From: [REDACTED]
Sent: 04 October 2018 14:10
To: Anita Gardner
Subject: Re: R/152/18/DOC - Landscaping condition - 2 Broadmark Lane, Rustington

I have today received the comments of the Landscape Officer. She has stated 'The information submitted in dwg 15/1091/02 rev C has not been supplied in sufficient detail. The landscape planting detail needs to be included in plan form with species choice and actual proposed plant numbers, densities and height at time of planting. The drawings submitted at present are lacking this detail. '

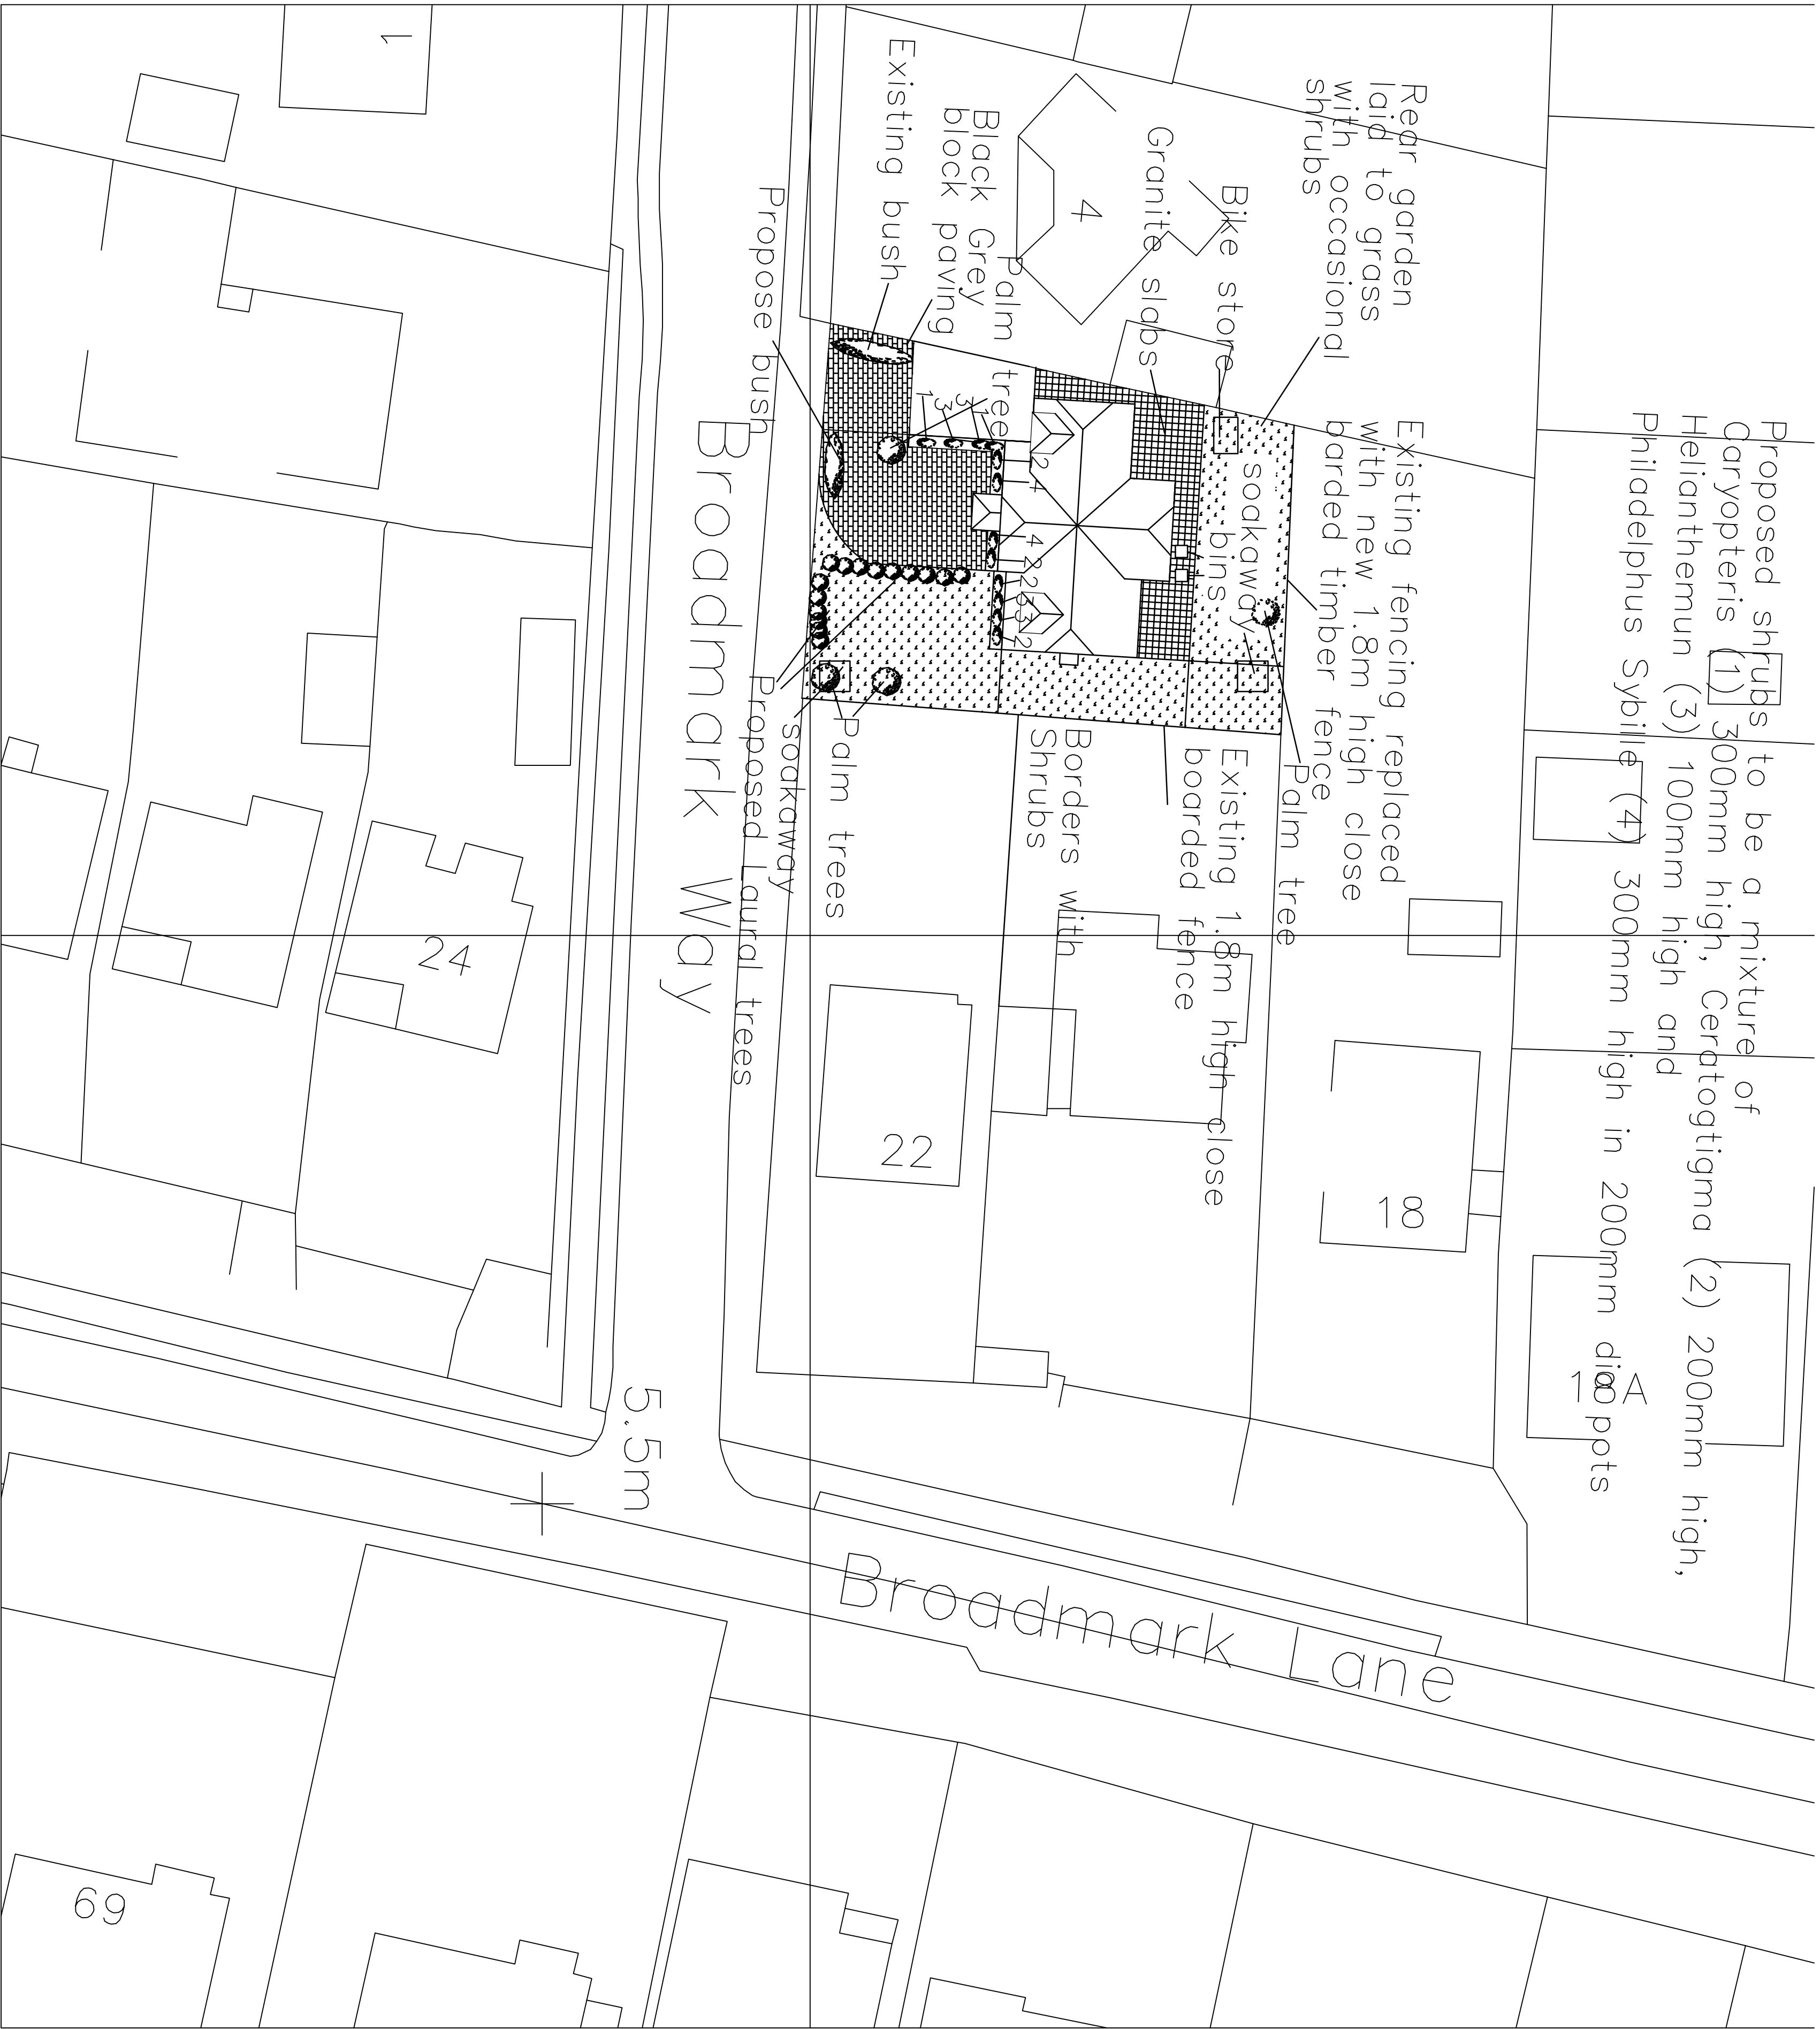
Dear Tony,
What about the size of the palm trees, the number and size of laurels on the site frontage and the bush on the site frontage? Can these details be confirmed please? They don't need to be indicated on plan, but I would appreciate conformation by e-mail which can then be added to the application.
Regards
Anita

The palm trees will be 900mm high, the laurels 900mm high as for the hedging.
